12255
8 June 2017

**SECTION 96(2) MODIFICATION APPLICATION SSD 7388 – MOD 3
31 WHEAT ROAD, SYDNEY**

On behalf of Grocon (Darling Harbour) Developments Pty Ltd we hereby submit an application pursuant to section 96(2) of the *Environmental Planning and Assessment Act, 1979* (EP&A Act) to modify SSD 7388 relating to The Ribbon development (former IMAX site).

1 GROUND FLOOR PLAN - LOCATION OF CLASS B BICYCLE PARKING AND END-OF-TRIP
1:250

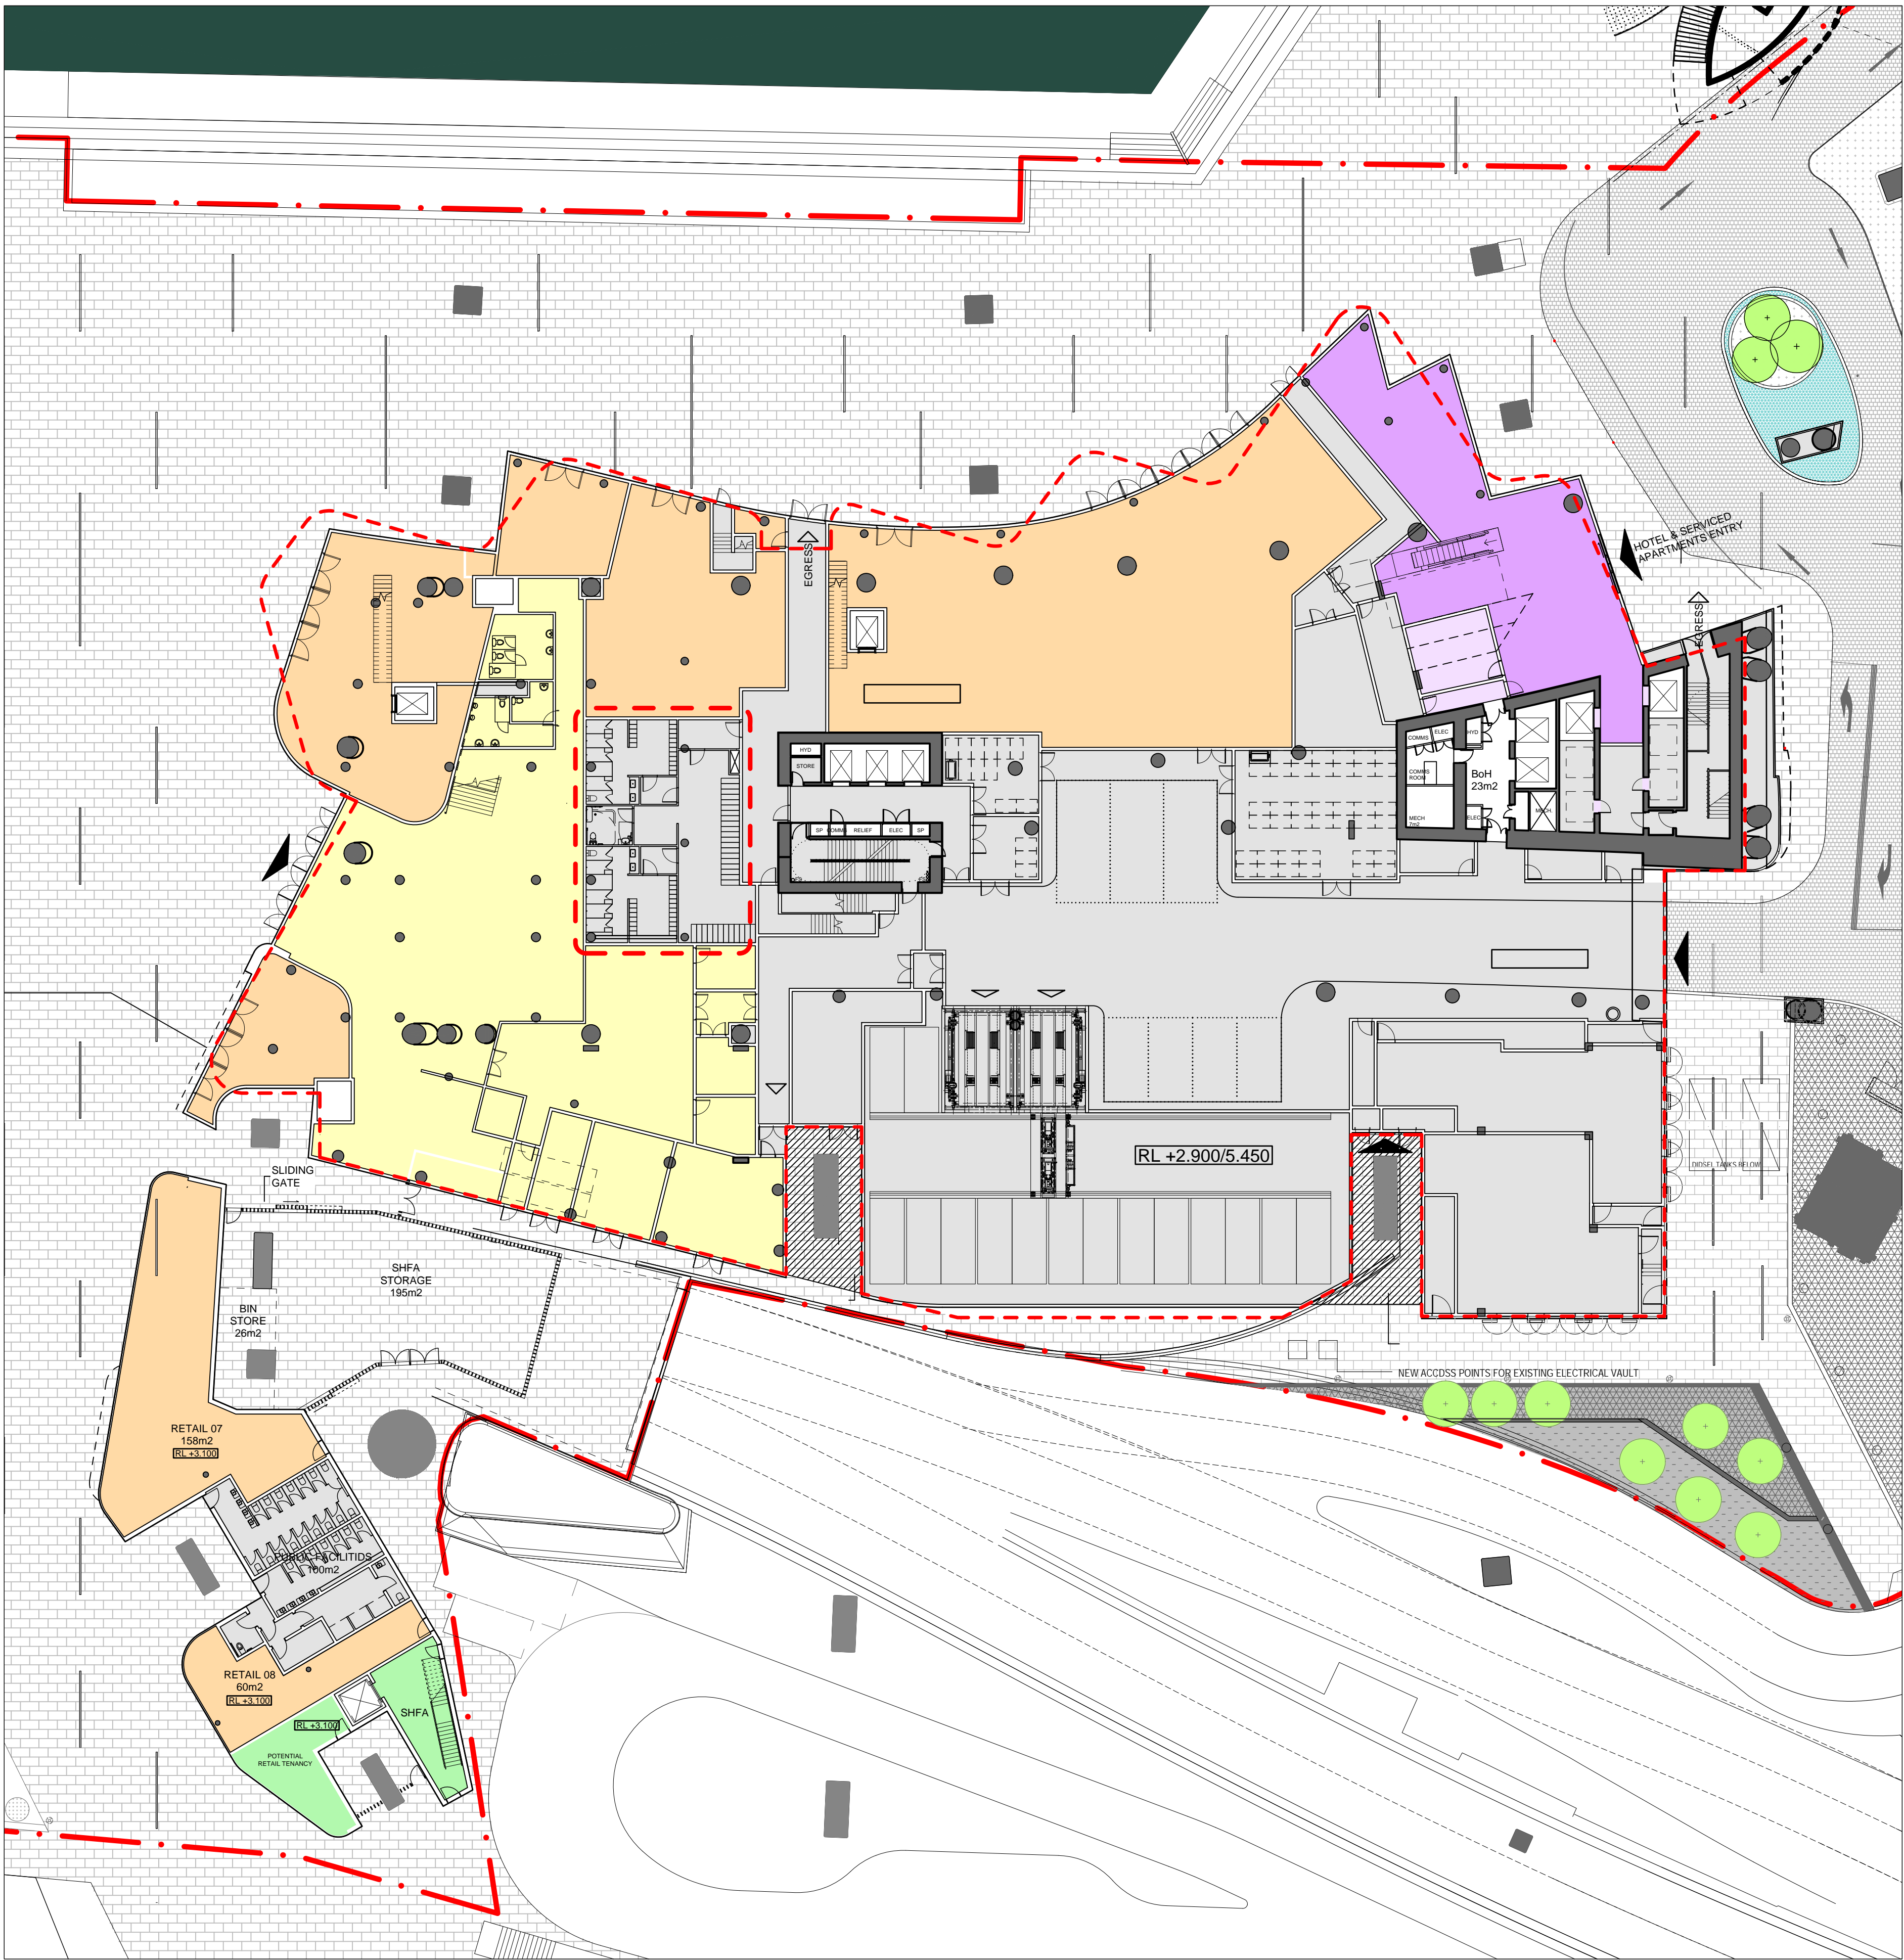
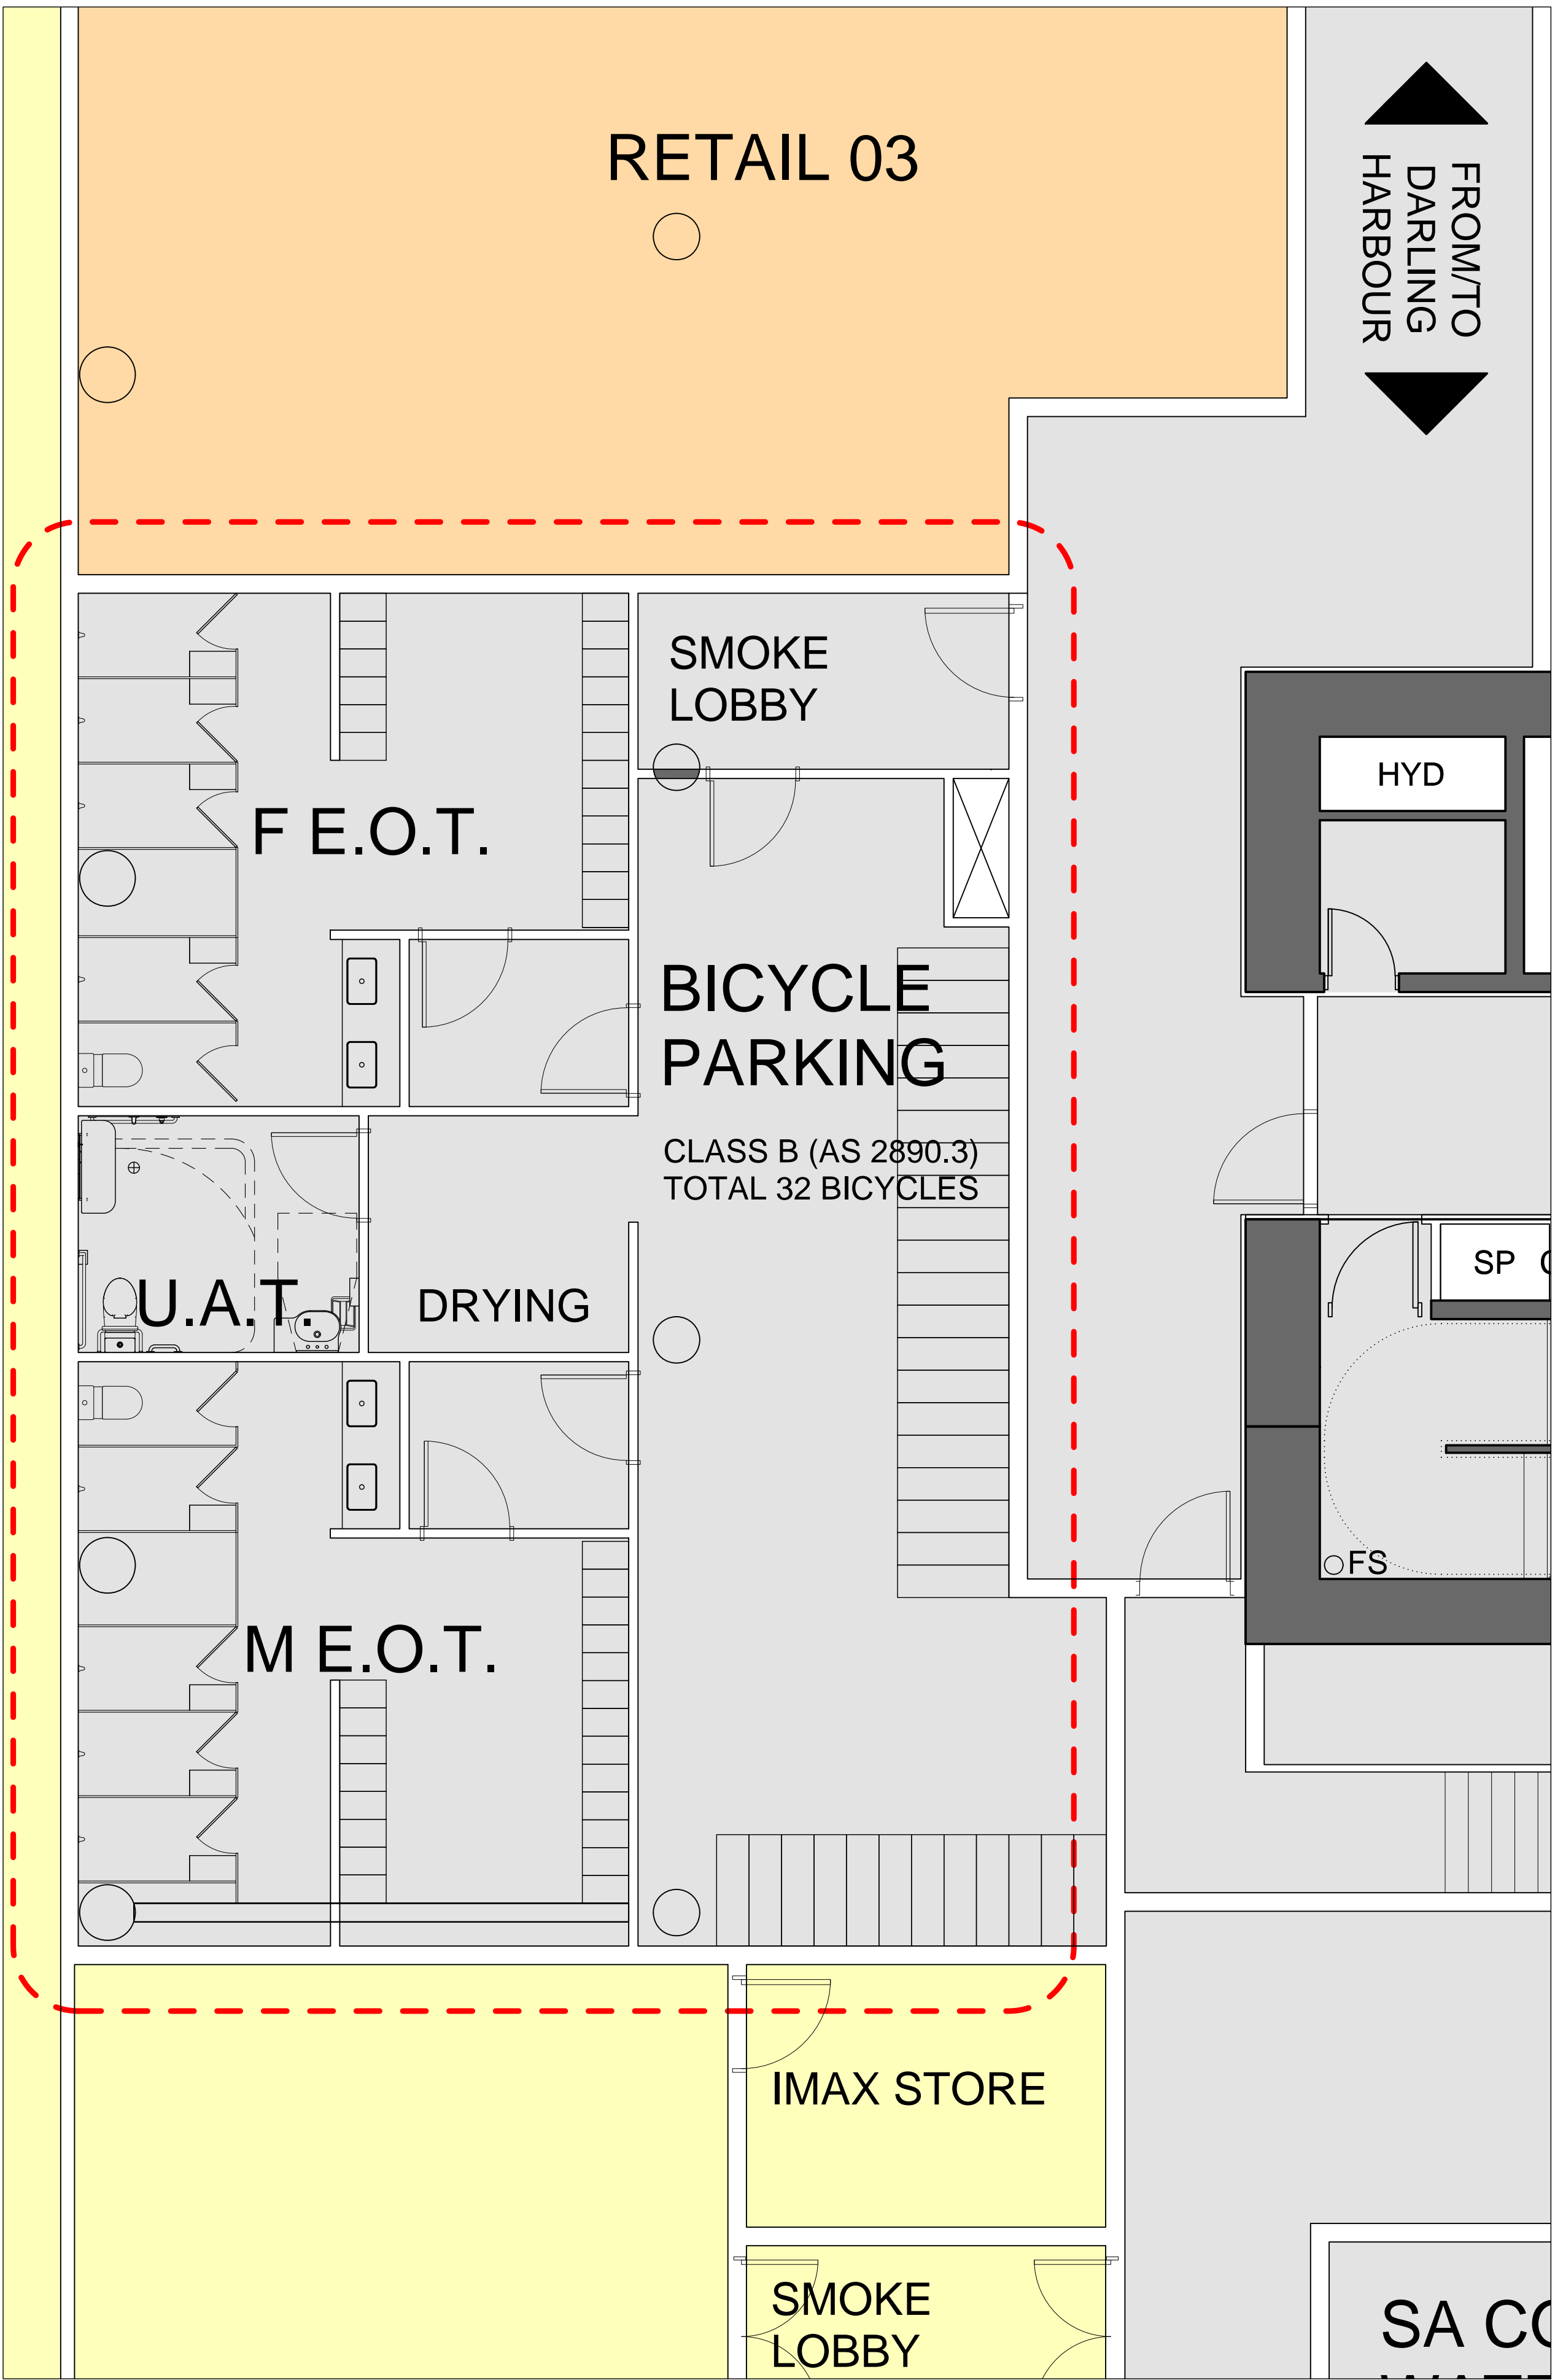
Grocon is seeking to reduce the number of bicycle parking spaces that are provided for hotel and serviced apartment guests of the development. The total number of bicycle parking spaces provided in the development has been determined by the Green Star rating scheme as opposed to Council's DCP requirements (which do not technically apply to the site). However, Cundall has now obtained agreement from the Green Building Council (refer **Attachment B**) that guests of the hotel and serviced apartment accommodation can be excluded from the 5% guests parking provision requirement. This reduces the total number of parking spaces required and it is therefore proposed to reduce the overall bicycle parking provision down from 239 spaces to 208 spaces.

In addition to the reduction in spaces it is also proposed to relocate the retail / IMAX visitor bicycle parking from within the building to the public domain. 32 spaces are to be retained within the building for staff and the remaining 176 spaces are to be relocated to the area nominated for cycle parking on the public domain plan prepared by Aspect Studios. The revised location proposed is considered appropriate given that these spaces will primarily service customers to the retail and IMAX tenancies and it would be inappropriate to provide access to internal back of house access to these visitors. Refer to the public domain plans at **Attachment C**.

- B10** The following bicycle parking is to be provided:
- a) a minimum of ~~239~~ **32** bicycle parking spaces within the ground floor level of the podium;
 - b) a minimum of ~~56~~ **176** visitor bicycle parking spaces shall be provided within the public domain, ~~with the ability to expand this area to accommodate 100 spaces if demand in the future.~~
